Subject: FW: PA/21/SE/AR/57583 - St Marys Catholic Primary School - Sport England Ref: PA/21/SE/AR/57583

Please upload as consultation for BR/16/21/PL

Sport England – Statutory Role and Policy

The Proposal and Impact on Playing Field

MUGA Pitch

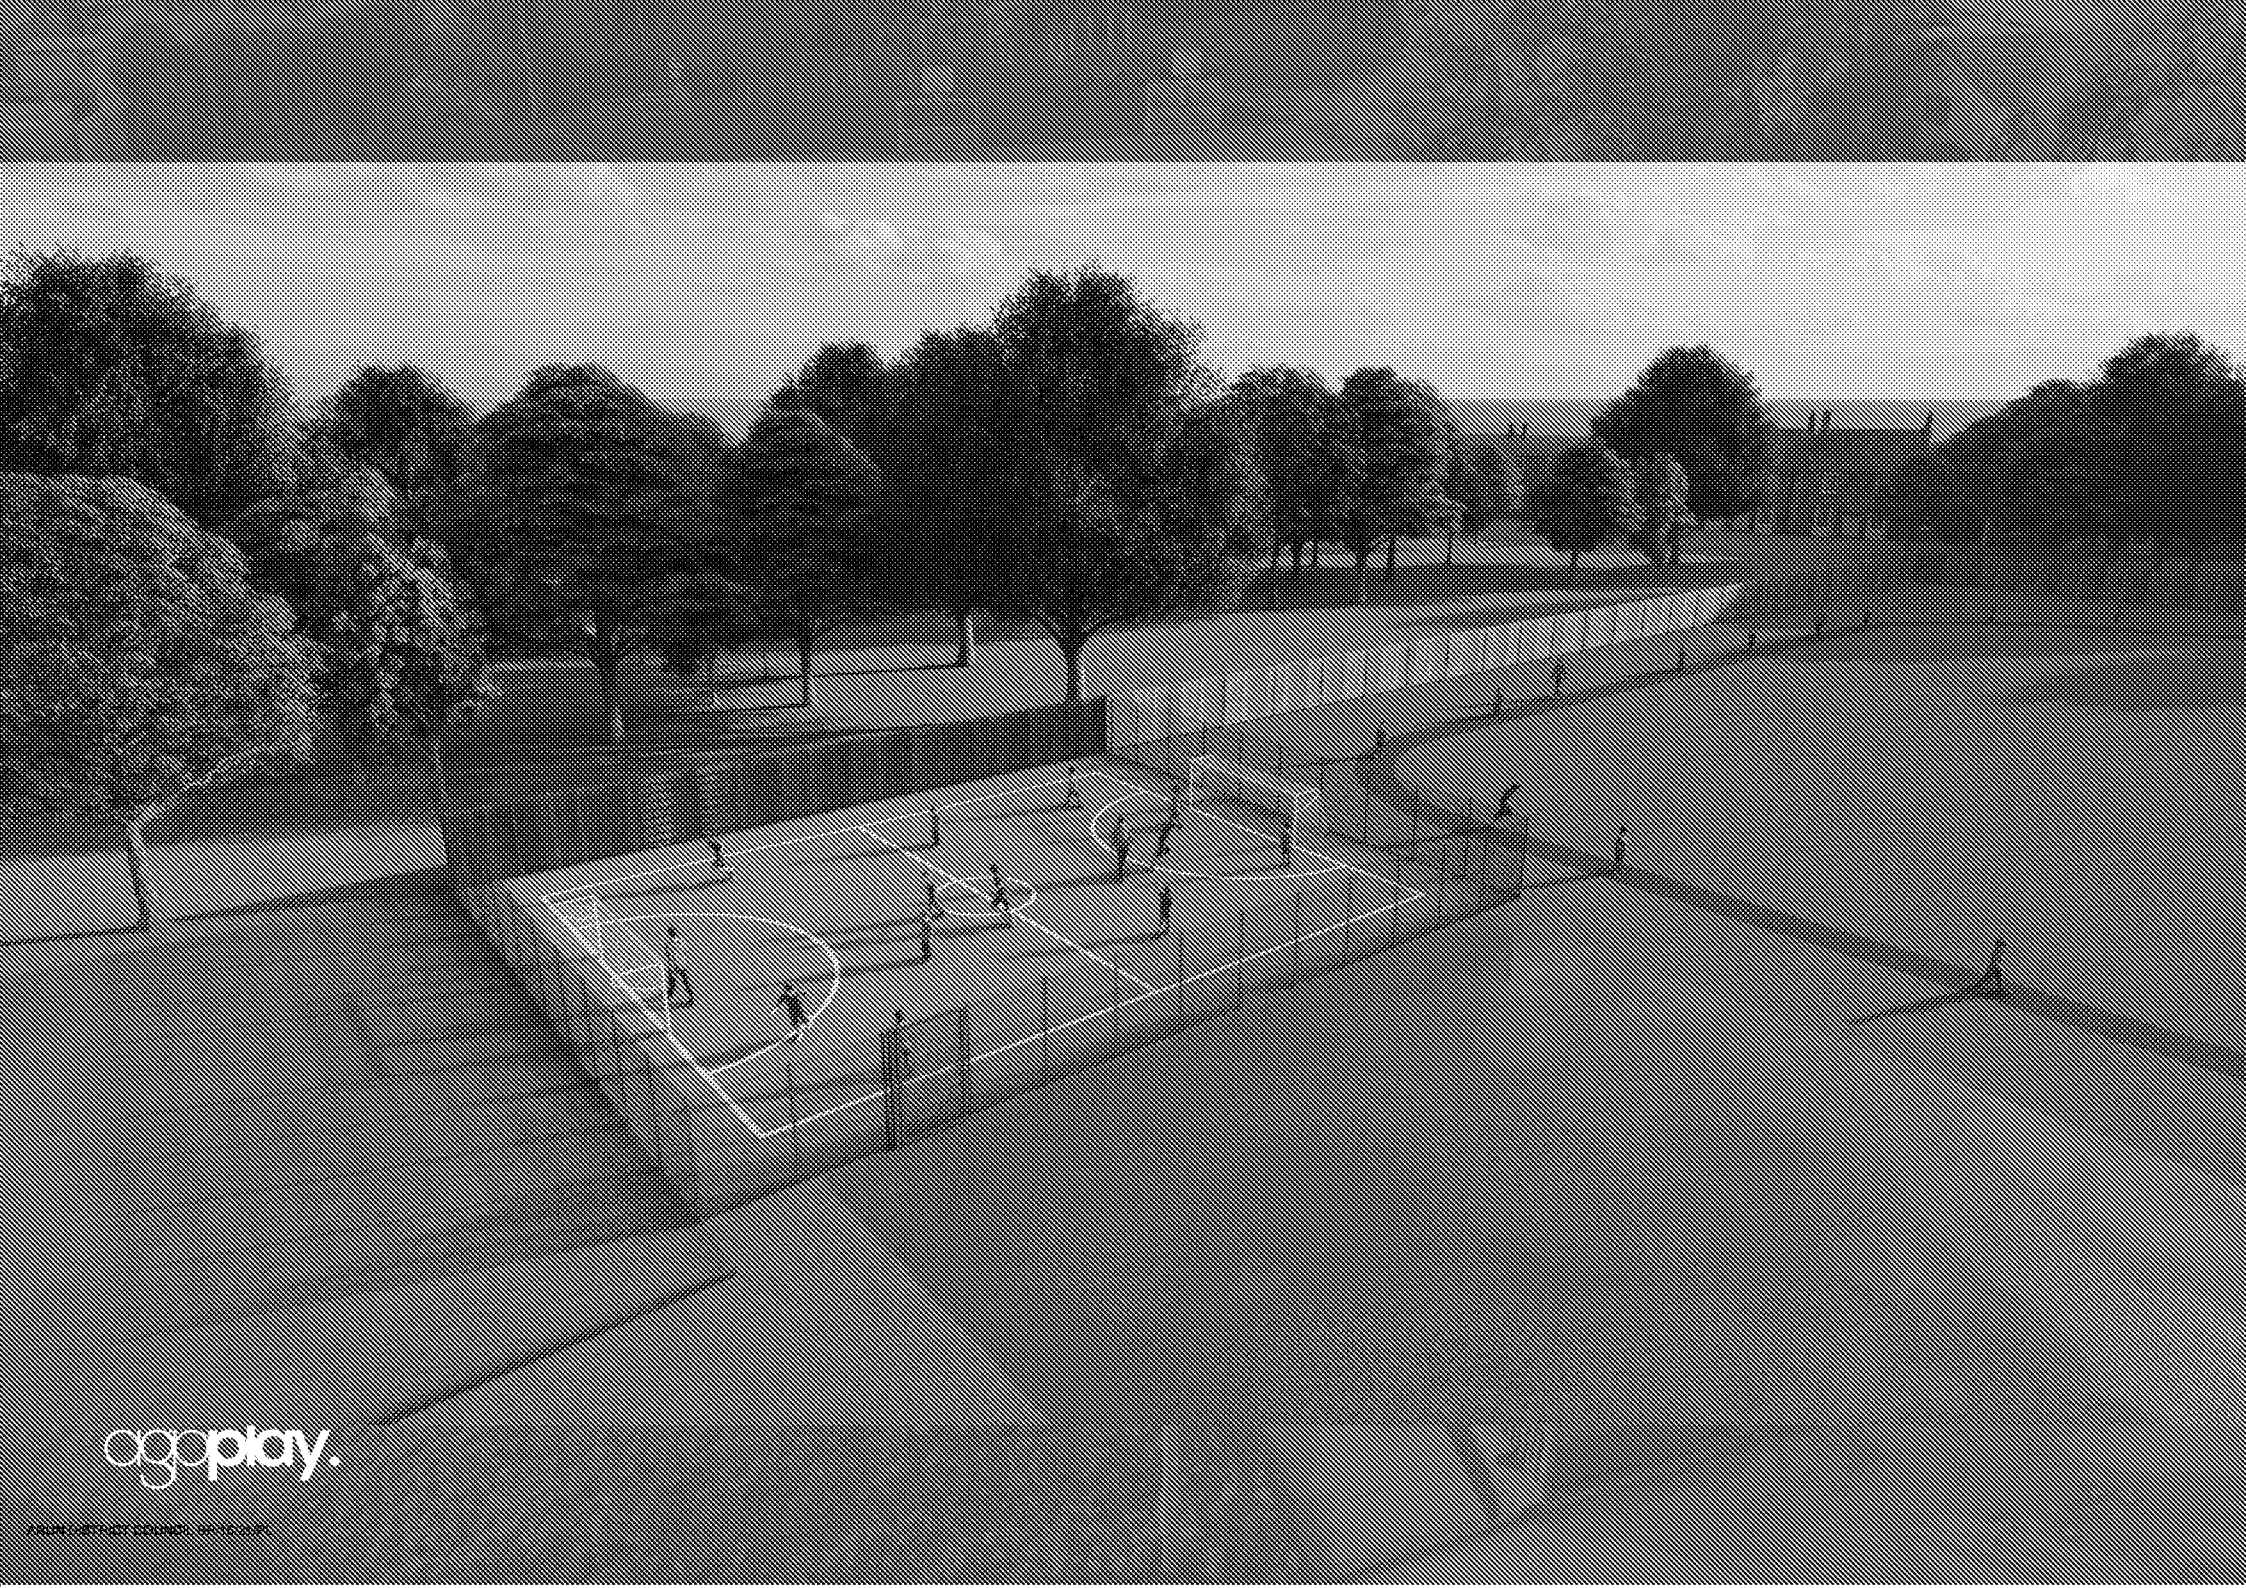
The proposal is for the erection of trim trail items, concrete games area, a MUGA (Multi Use games Area) with an artificial grass pitch, Daily Mile Track and Clamber Stack. Daily mile track will split the playing field into two and thereby limit the size of pitches which can be laid out.

The proposed MUGA is not to a recognised size and there is an existing MUGA on site. The applicants have not sought to justify the sub-sized MUGA.

The daily mile splits in two a large playing field reducing the size of playing pitches which can be marked out. An U9/U10 can be fitted on the playing field but this will not be possible if the daily mile track is installed in the position proposed.

The forest climber-clamber stack is deep into playing field and impedes playing pitch layout.

I would suggest move the forest climber-clamber stack to the edge of the playing field, outside the pitch zone. I would also suggest putting the daily mile track around the outside of the playing field. Notwithstanding these suggestions, a robust planning statement address the National Planning Policy Framework and Sport England’s planning policy will be required to support any amendments.
